**WELWYN HATFIELD BOROUGH COUNCIL
EXECUTIVE DIRECTOR - PLANNING, PUBLIC PROTECTION AND GOVERNANCE**

DELEGATED APPLICATION

Application No: 6/2021/1831/HOUSE
Location: 35 Northaw Road East Cuffley Potters Bar EN6 4LU
Proposal: Partial demolition of the bungalow, erection of single-storey side and rear extension, extension of roof to form loft conversion with side dormers and alterations to the front facade, insertion of skylights
Officer: Ms Emily Stainer

Recommendation: Granted

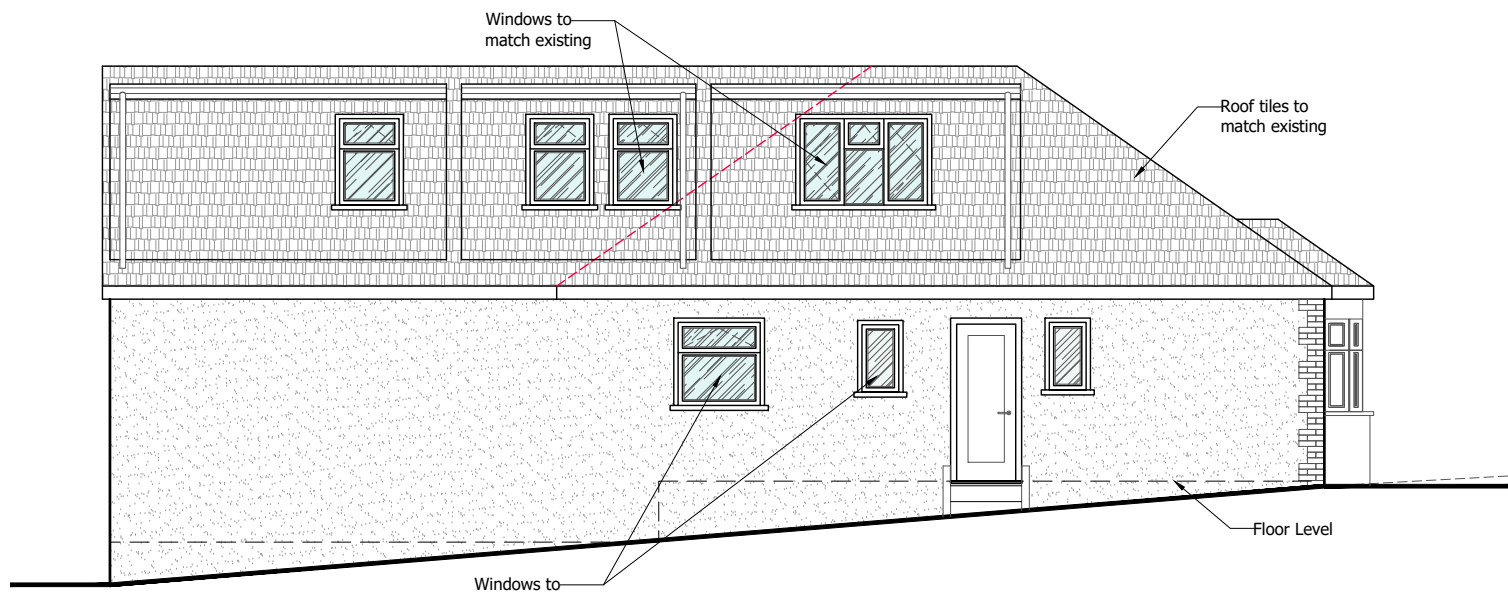
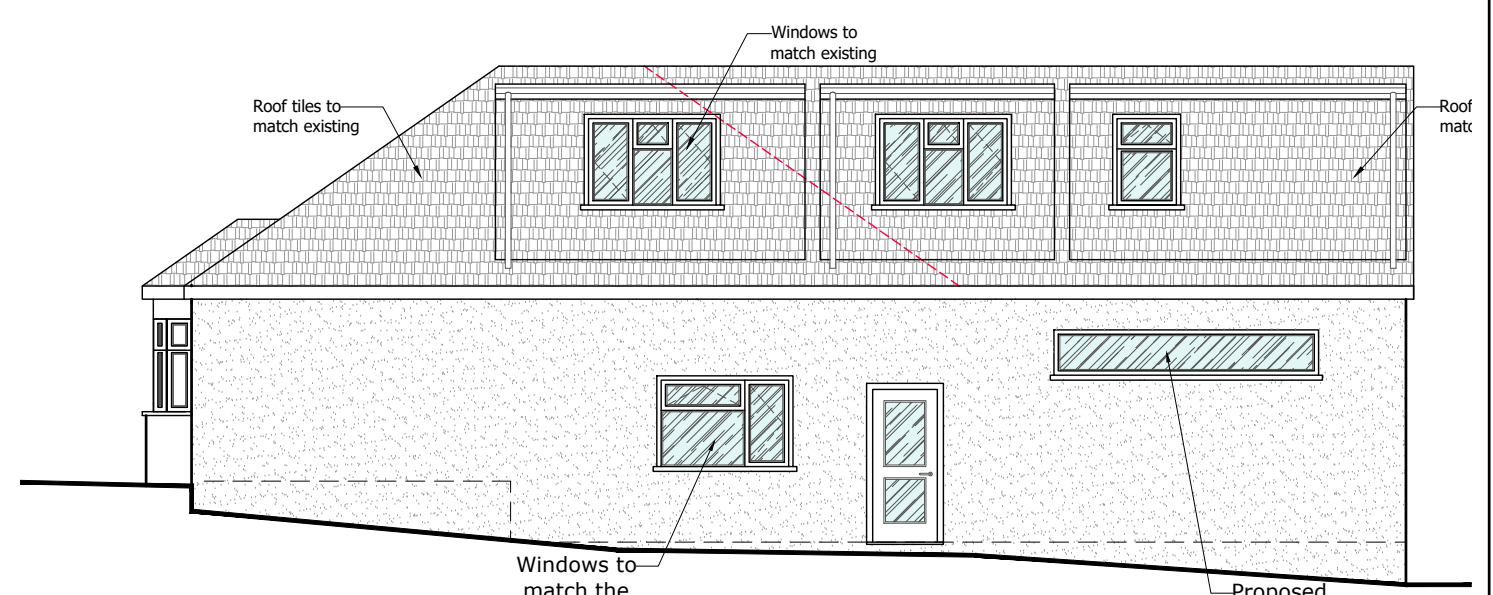
In terms of overlooking, one of the new bedrooms at first floor would only have one window which is

side facing, towards the neighbouring property at 37 Northaw Road East. It would not be appropriate to restrict the only window to this habitable room to be obscure glazed and fixed as this would result in undesirable living conditions for the future occupiers of that room. As the property presently benefits from two bedrooms at ground floor level which have side facing windows (one facing the flank wall of No.37 and the other with a window into the attached garage), the relocation of the bedrooms to the loft space, even with one with a side facing window, would represent an improvement above the existing situation. It is acknowledged that the window would overlook 37 Northaw Road East to some extent, but due to the single storey nature of that property it would overlook the roof rather than any habitable windows.

All of the other side windows at first floor (with the exception of a walk-in wardrobe) are labelled as obscure glazed on the plans. To prevent overlooking to neighbours and ensure that the works do not prejudice the ability of adjacent occupiers to convert the loft space in future, it is considered reasonable and necessary to impose a planning condition which requires all side windows at first floor to be obscure glazed and fixed below a height of 1.7m above floor level, with the exception of the window to bedroom 2. This is acceptable as the remaining bedrooms would all have windows to the front or rear of the house with a sufficient outlook. Views from windows within the rear elevation would predominantly be to the rear garden of the application site. Whilst some additional overlooking to neighbouring gardens may result, this would not be sufficiently harmful to warrant refusal of planning permission on these grounds.

1. With the exception of the side window serving bedroom 2 on the drawings hereby approved, all upper floor windows located in a wall or roof slope forming a side elevation of the building hereby approved must be obscure-glazed and non-opening unless the parts of the window which can be opened are more than 1.7 metres above the floor of the room in which the window is installed, and shall be retained in that form thereafter.
